From: Fiona West [REDACTED]
Sent: 19 October 2015 21:22
To: Simon Davis
Subject: P/86/15/PL

Could I please add my points below in relation to the response from Ivon Blumer Architects, to Planning Application No. P/86/15/PL. at 11 Abbottsbury.

PROJECT	11 Abbotsbury Road	DATE	23 June 2015
TITLE	Proposed Plans and Elevations	DRG NO	IBA/433/02
SCALE	1 : 100	REVISIONS	A

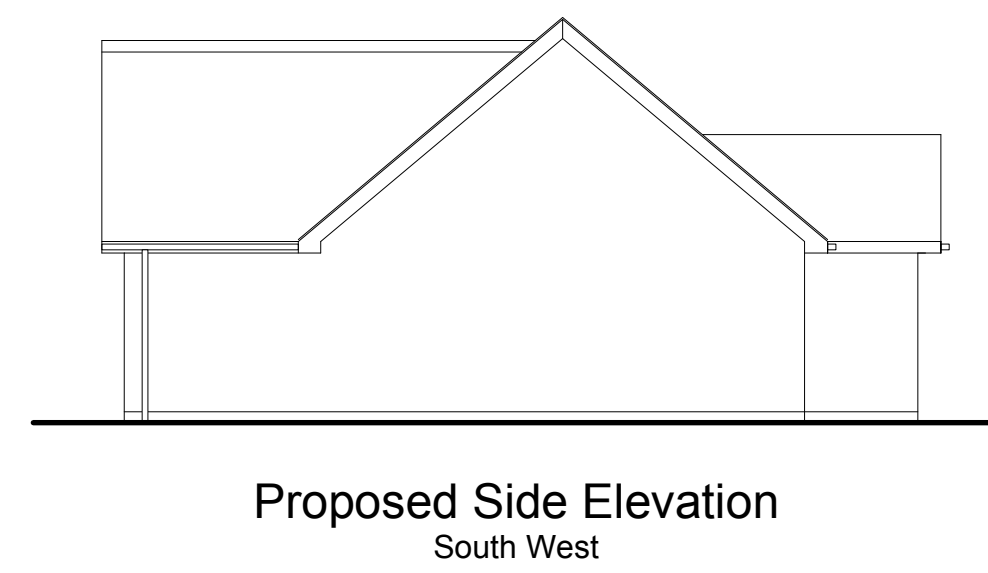
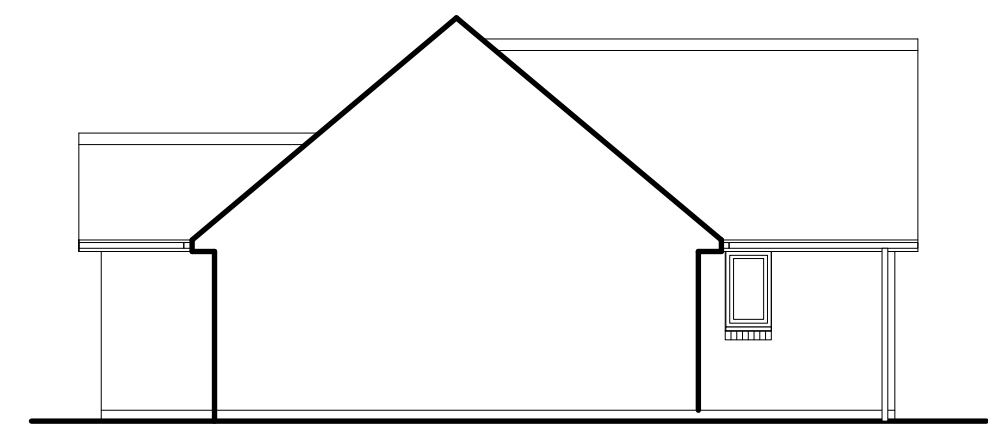
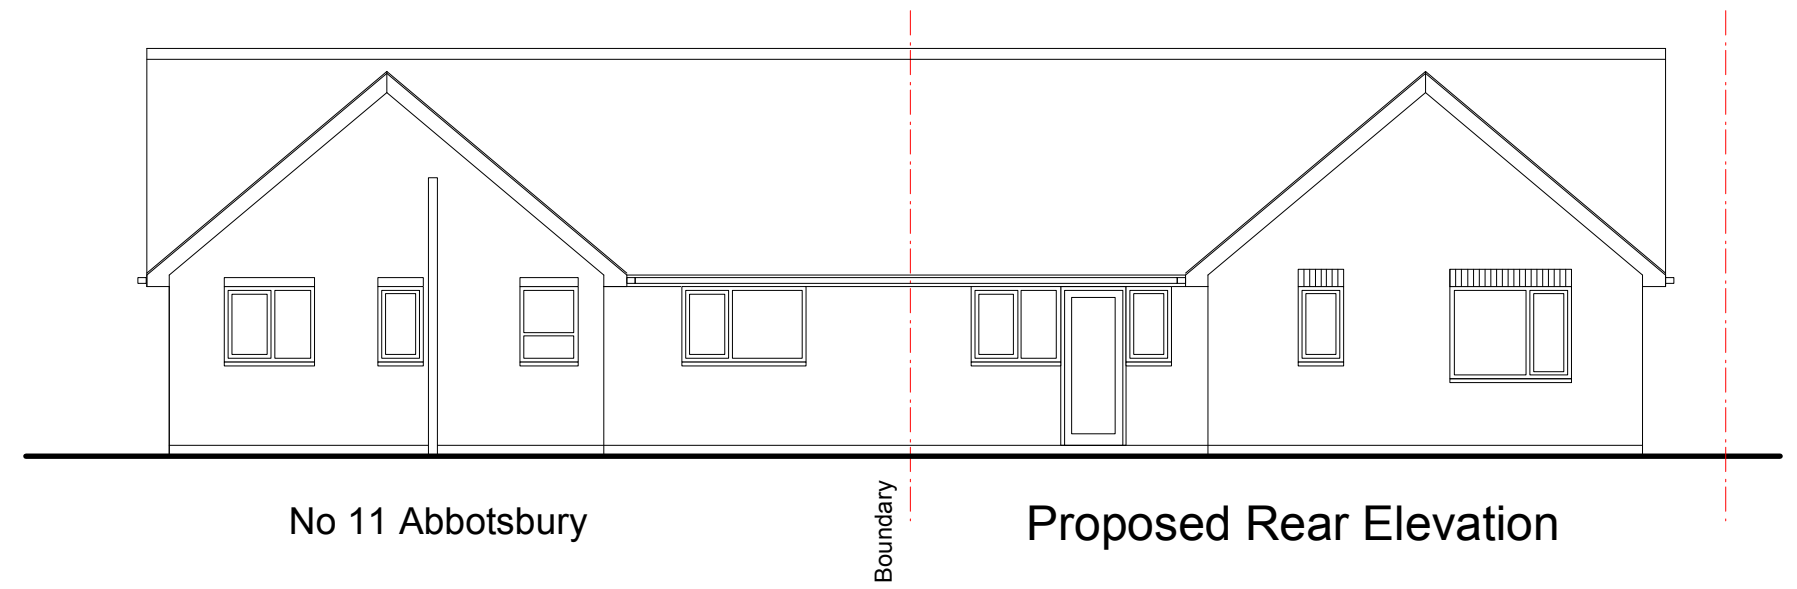
We still feel that a loss of natural day light is going to be an issue in the Kitchen window and both bathroom windows and possibly the conservatory, as the roof line is going to be much higher than the existing garage roof line. This will take away any natural light into these windows. (please see from the pictures attached, if this is to be filled with the apex of the roof you can see what will be lost)
